From: Clare Dales
Sent: 21 March 2018 09:00
To: Ross Leal
Cc: Martyn White
Subject: RE: Please find attached amendment on planning application Ref: CM/30/17/L

APPLICATION **CM/30/17/L**
NO:

Registered: 28-NOV-17
Site Address: The Dairy Brookpit Lane Climping BN17 5QU

Description of Works: Listed building consent for new front door, porch roof over, remove internal wall on first floor, new ballustrading on first floor, new internal window on ground floor & removal of partition walls on ground floor.

Job Title	The Dairy Brookpit Lane, Climping		
Client	Antoinette Wilks		
Drawing Name	Plan and Elevations Proposed		
Drawing Status	Planning		
Drawn by	AF	Date	Aug 17
Checked by		Date	
Drawing Scale	1:100 at A2		
Drawing No	171128/ 02	Status	Revision
			A

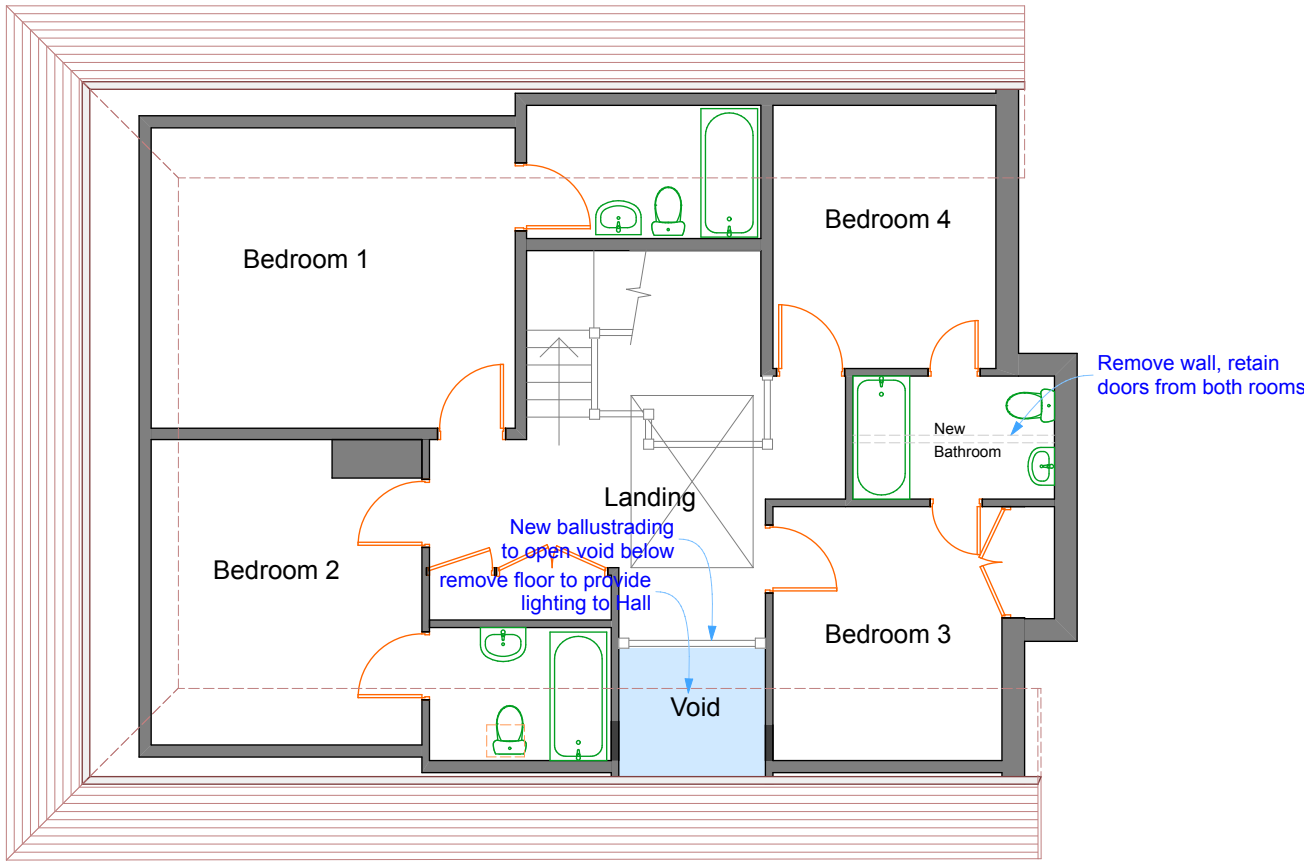
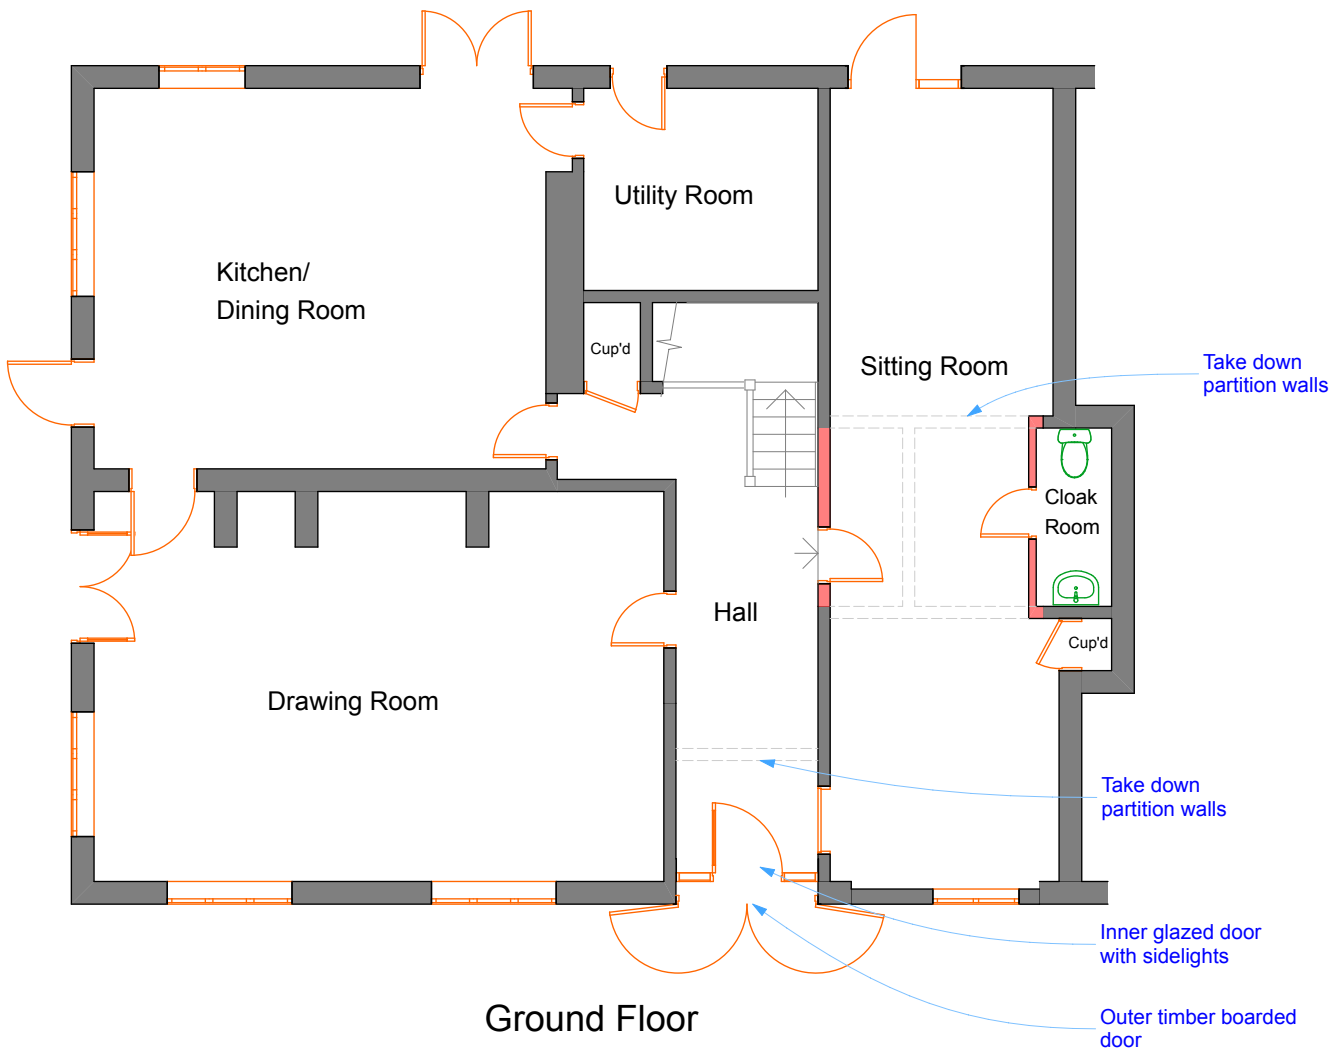
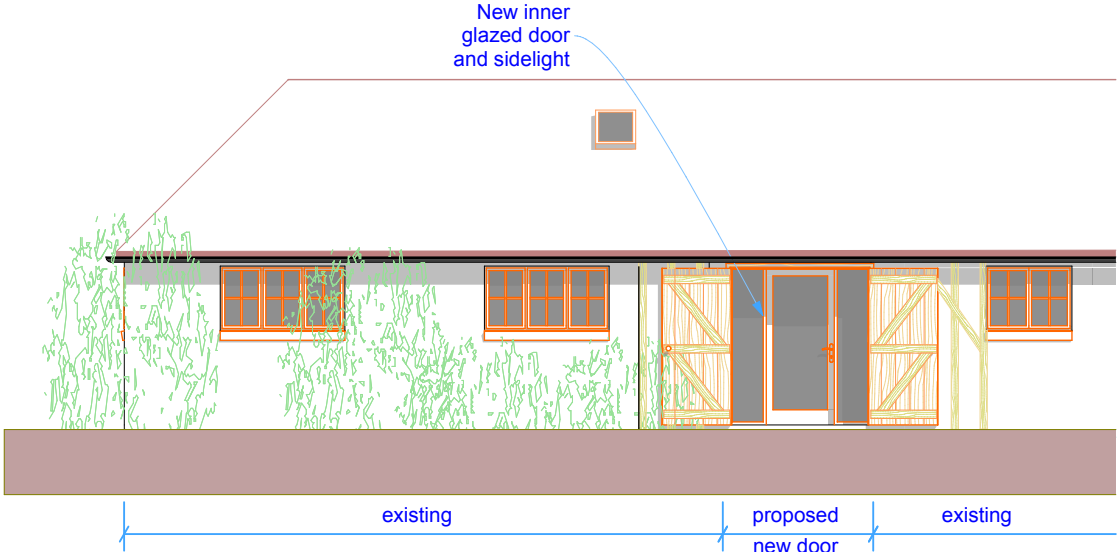
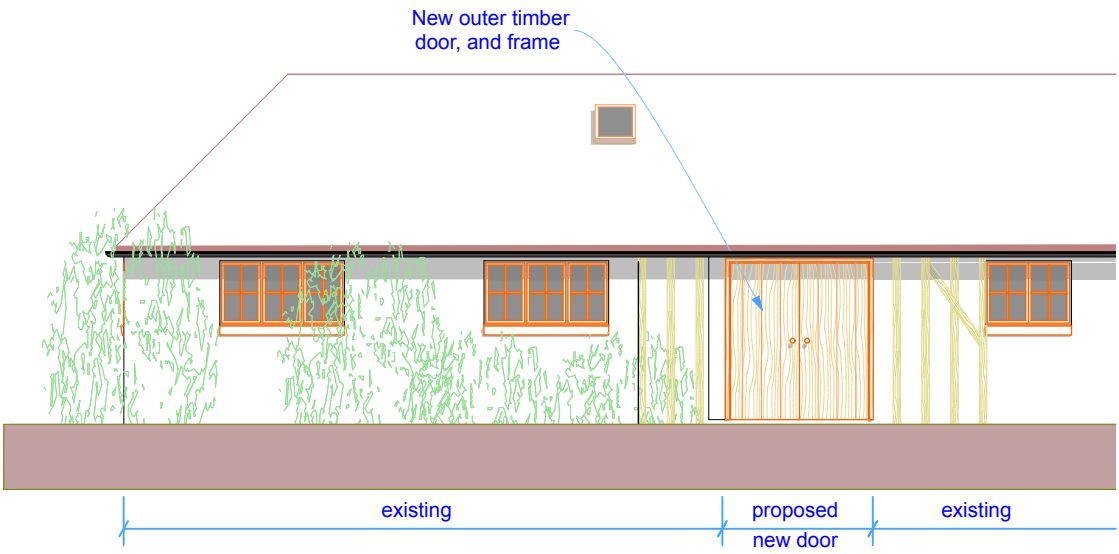
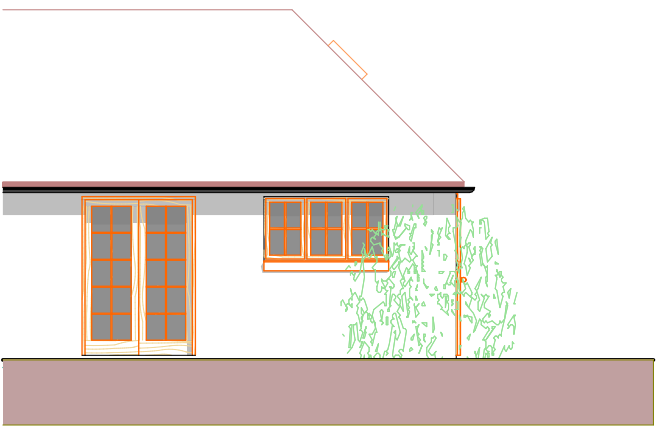
Thank you for inviting me to comment. I find the revised plans regarding the proposed internal works and new door acceptable as detailed (subject to condition, including joinery design and finishes). I note, however, that there is no mention of roofing works. This is essential to halt the ingress of water to the building, as described/shown to me during my last site visit. I was expecting this to be part of the application, and not it is omitted. Any roofing works would need LBC.
